DRB Application No.: _____ Project # 1008695
Project Name: Remodel Exist. Truck Wash Facility
Agent: BILL BURK, ARCHITECT Phone No.: 292-6566

DEVELOPMENT REVIEW BOARD MEMO

**City of Albuquerque
Planning Department
Inter-Office Memorandum**

SUBJECT: Project # 1008695

Project Title	Project Manager	Project ID
REMEDIATE EXISTING TRUCK WASH FACILITY for El Paso-Los Angeles Limousine Express, Inc. 2901 Pan American Fwy NE, ABQ, NM	Bill Burk	#09-29
Drawn By	Scale	As Shown
Chris Burk		
Date	Drawing No.	1 of 2
6/9/11		
CAD File Name

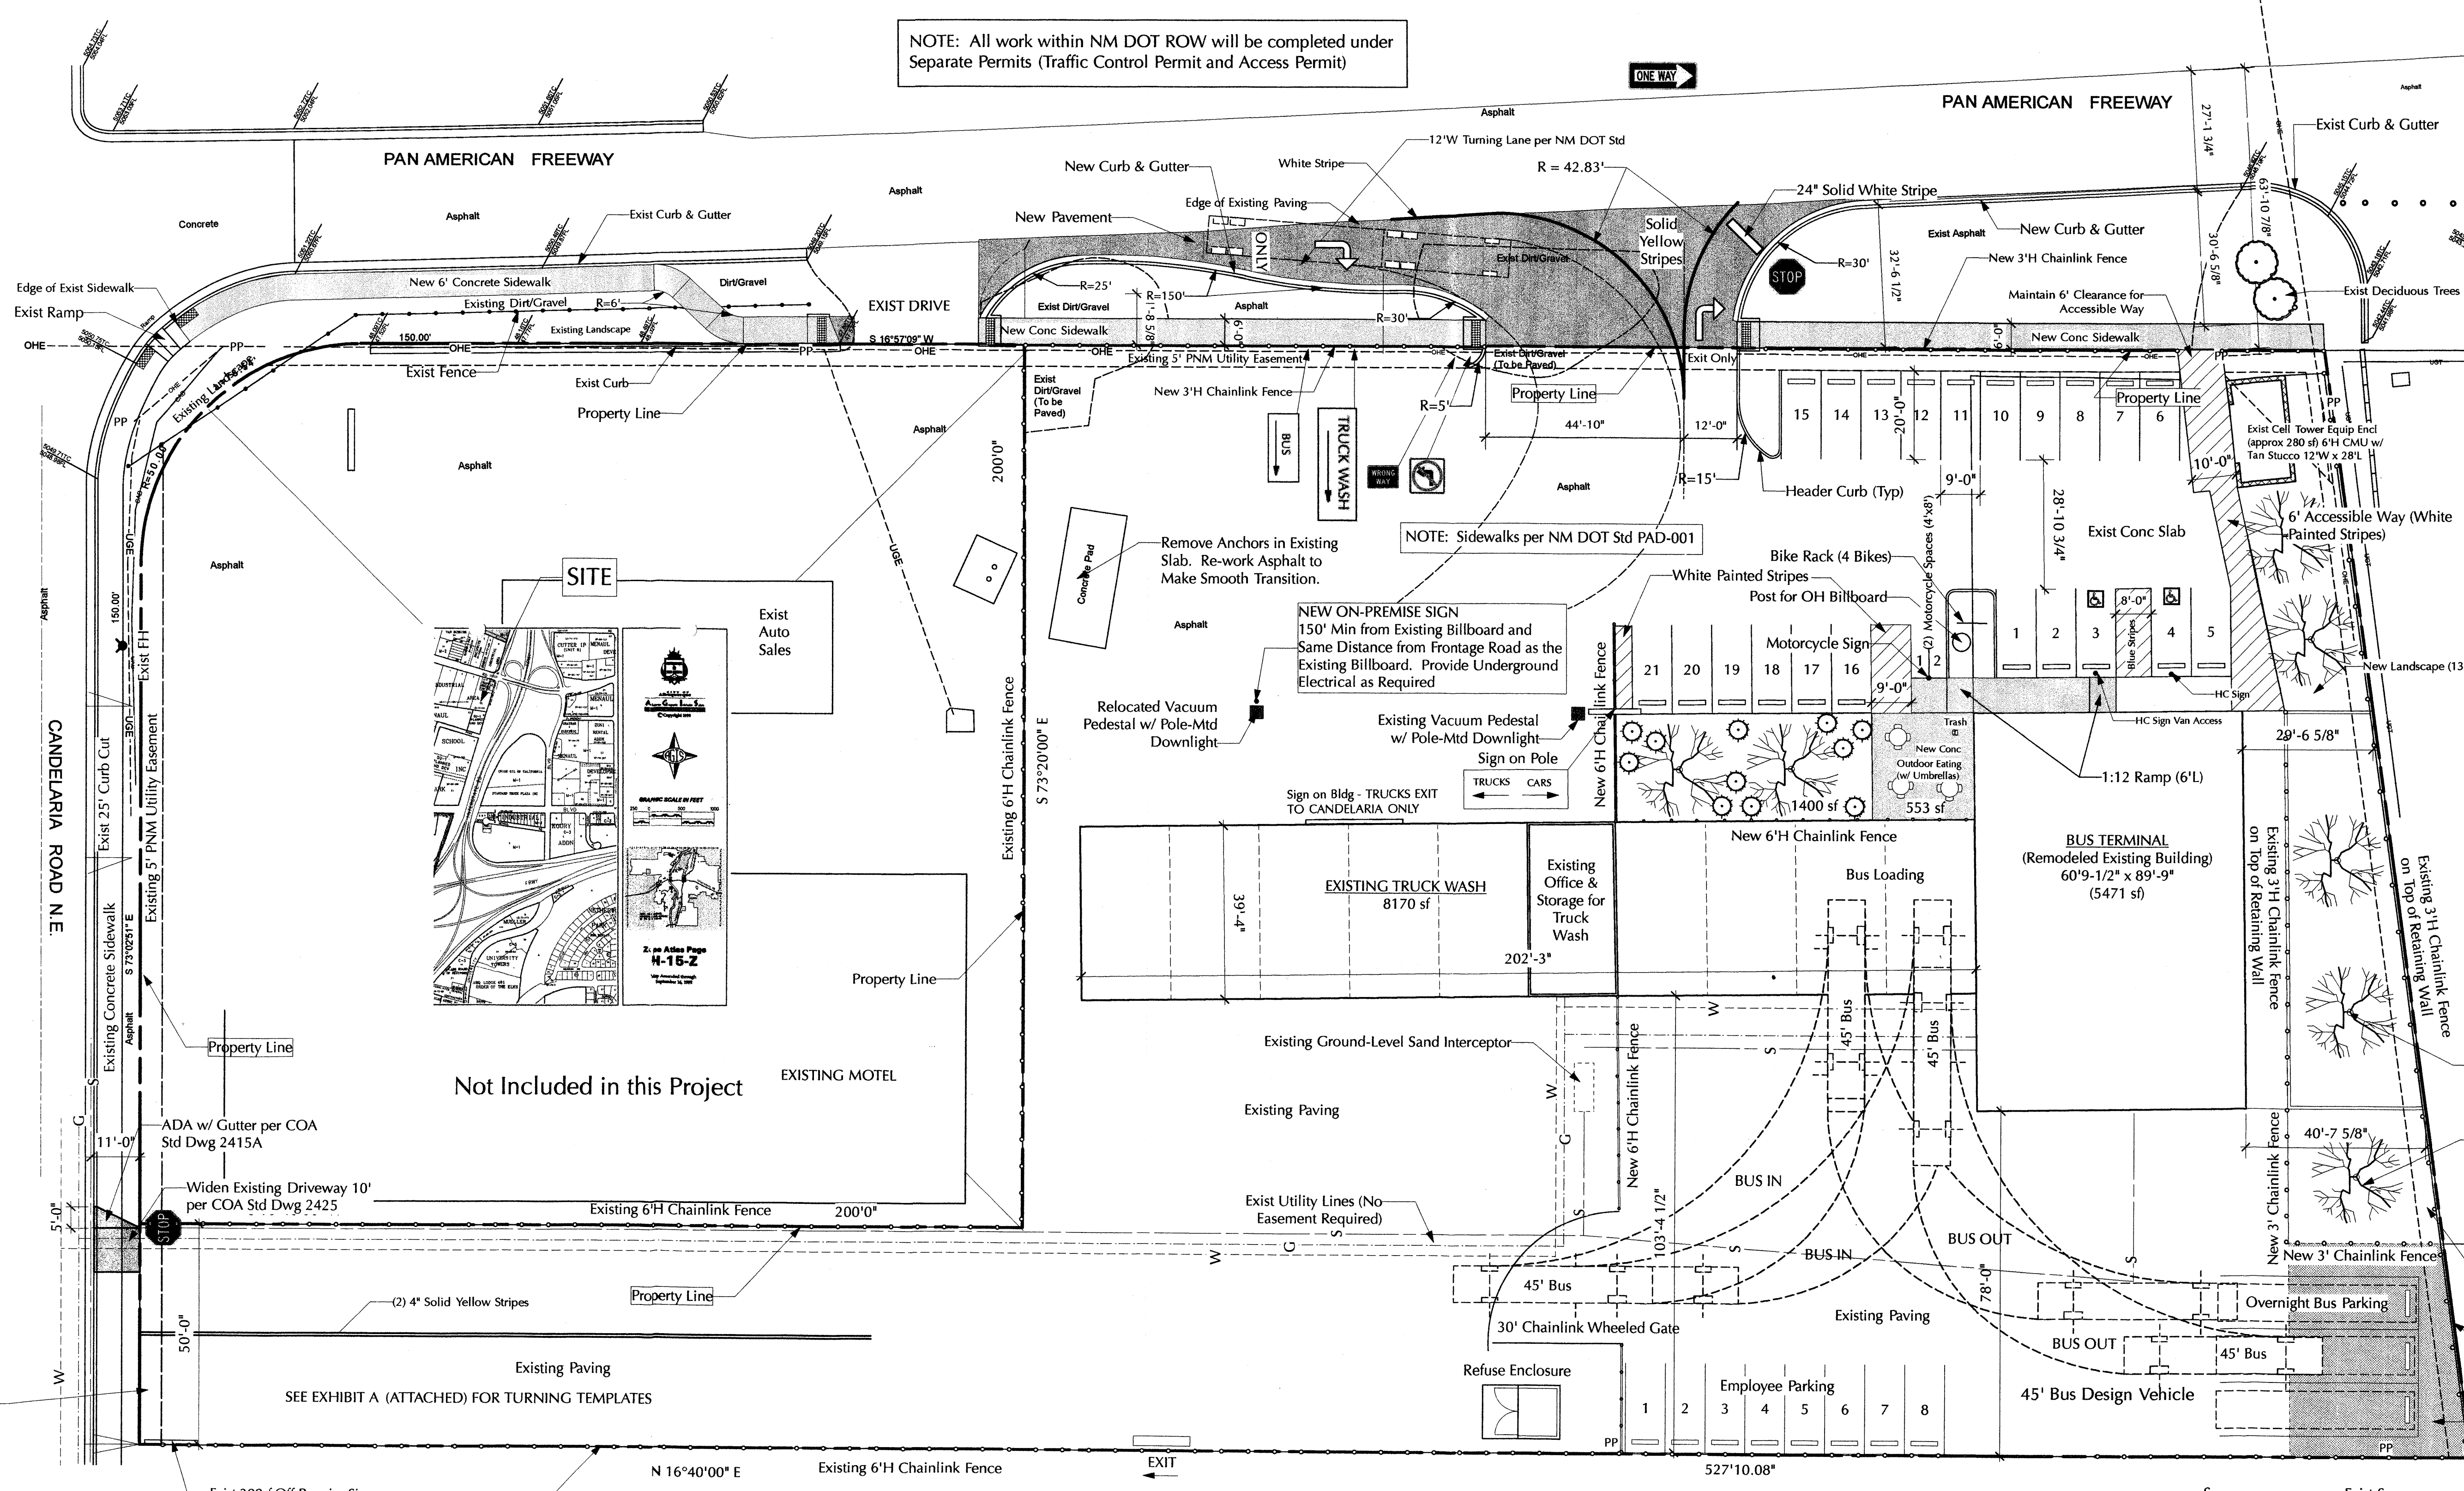
The applicant has generally satisfied the EPC conditions of approval for the site development plan for building permit. Sheet 2, Architectural Elevations, as reviewed and approved by the EPC, was not *included in this submittal. This sheet needs to be added to the final site development plan, which should be numbered accordingly.* Staff has the following comments regarding EPC Conditions of Approval:

2. Conditions of Approval from the City Engineer:
 - a. The design vehicle classification is not shown on the site plan. The applicant states that the turning template exhibit has been provided to the City Engineer.

- c. NMDOT approval has not been demonstrated.
3. Conditions of Approval from PNM: On 6/24/11, a PNM representative stated that the proposed desert willow tree species is acceptable, because it is less than 25-feet tall at full maturity, and that there are no other outstanding issues.

4. Staff recommends that Condition #4, which is actually a Finding, should be added to the site plan in order to facilitate potential future revisions to the amount of parking provided.

7. Condition #7, regarding a pedestrian sidewalk connection to Candelaria Rd. is provided along the front of the property within the NMDOT frontage road right-of-way. This facility meets the intent of the EPC Condition of Approval.

1. A note has been added to the Site Development Plan, stating that all work within the NMDOT right of way will be completed under separate permits (Traffic Control and Access).

3. A Site Distance Exhibit has been added to the Site Development Plan.
4. The dimension from the face of curb to the property line has been added to the Site Development Plan.

5. The accessible way has been revised on the Site Development Plan.
6. The pavement limits have been clarified on the Site Development Plan.
7. The dirt areas along the east property line are to be paved, and are so shown on the Site Development Plan.

8. The sidewalk along the frontage road has been extended and widened to 6 feet on the Site Development Plan.
9. The parking has been revised, to clarify spaces, add striping, radii and islands

10. Additional turning templates are shown on the Site Development Plan. Scaled templates have been filed with the City Traffic Engineer.
11. The westernmost pond has been re-labeled "Mud Disposal Pond", to match the site plan on file (there is no Grading and Drainage Plan).
